**RE: Lot 12 Block 7 Unit 5, S.A.D. 227  
8035 Kibo Pl. NW  
Grading and Drainage Plan E10D090  
Engineers Stamp Date 12/10/2020 by David Soule  
BP Stamp Date 12/10/2020 by David Soule  
CO Stamp Date 1/3/2022 by Riza Afaghpour**

Based on the Certification received 1/12/2022, the site cannot be accepted for release of Certificate of Occupancy by Hydrology until the following comments are addressed.

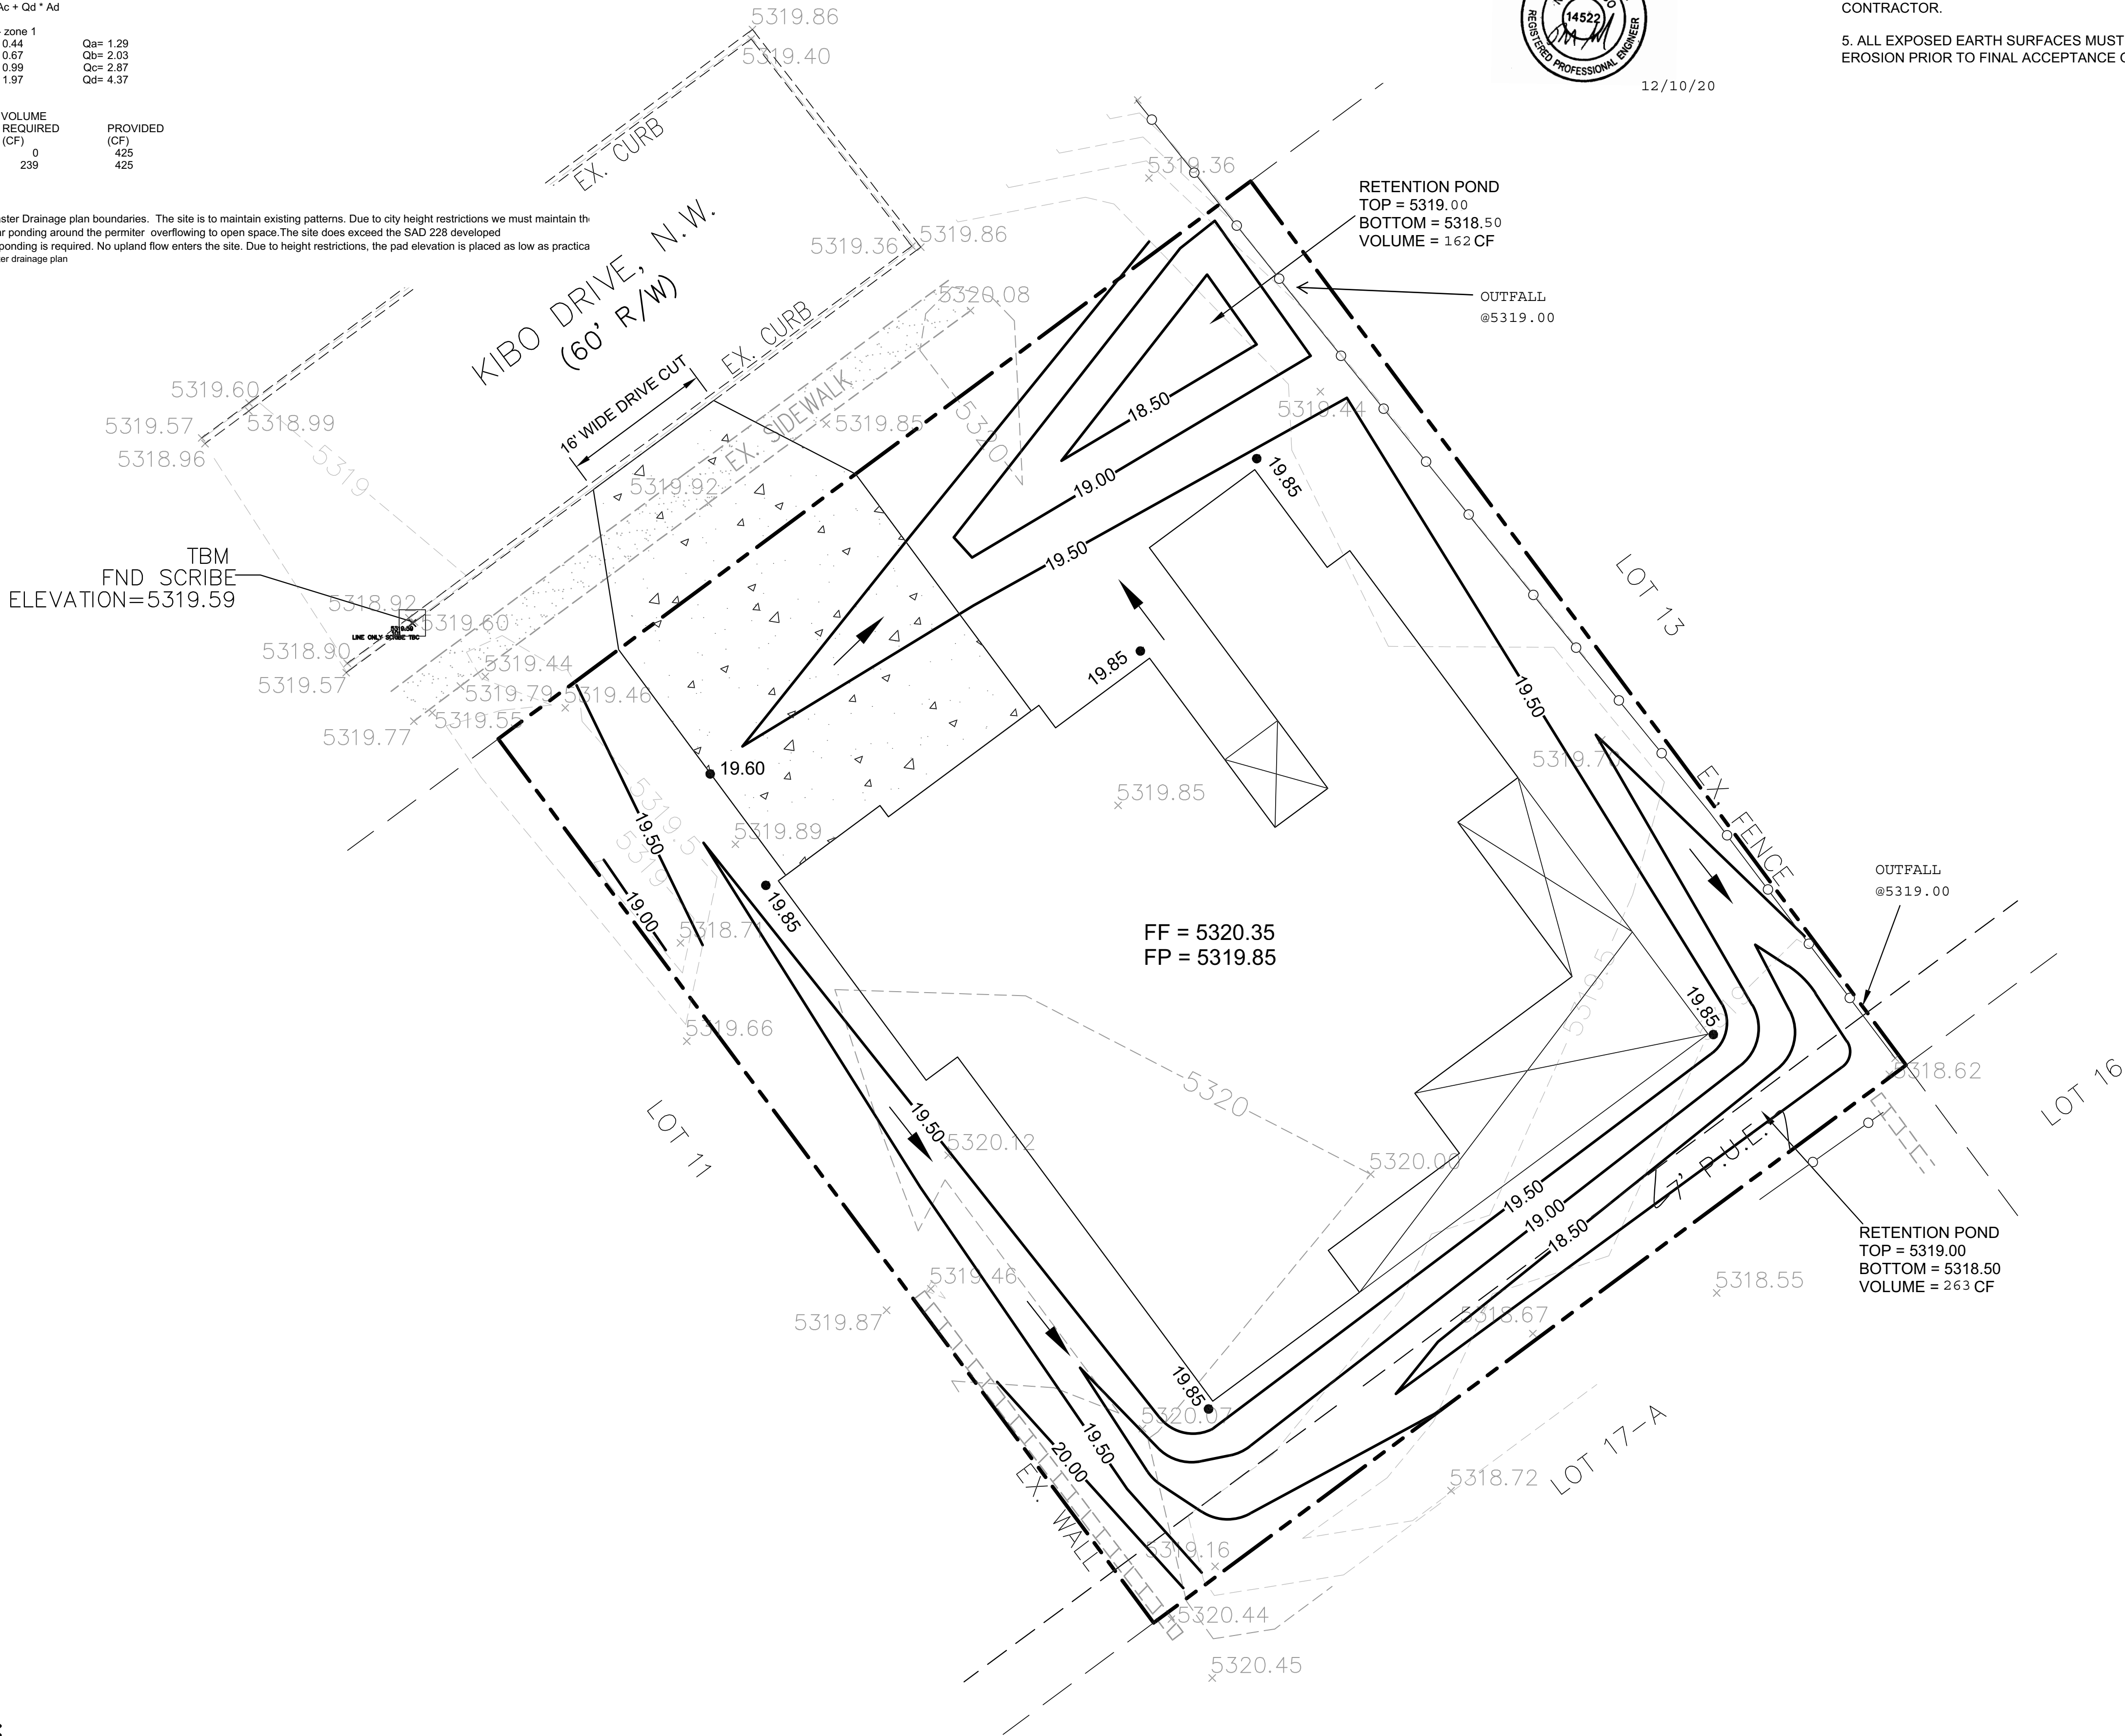
- A written letter of approval from David Soule to use his plan for CO.
- Required Ponds are not in place.
- The south yard area is allowing flows to enter neighbor's yard.
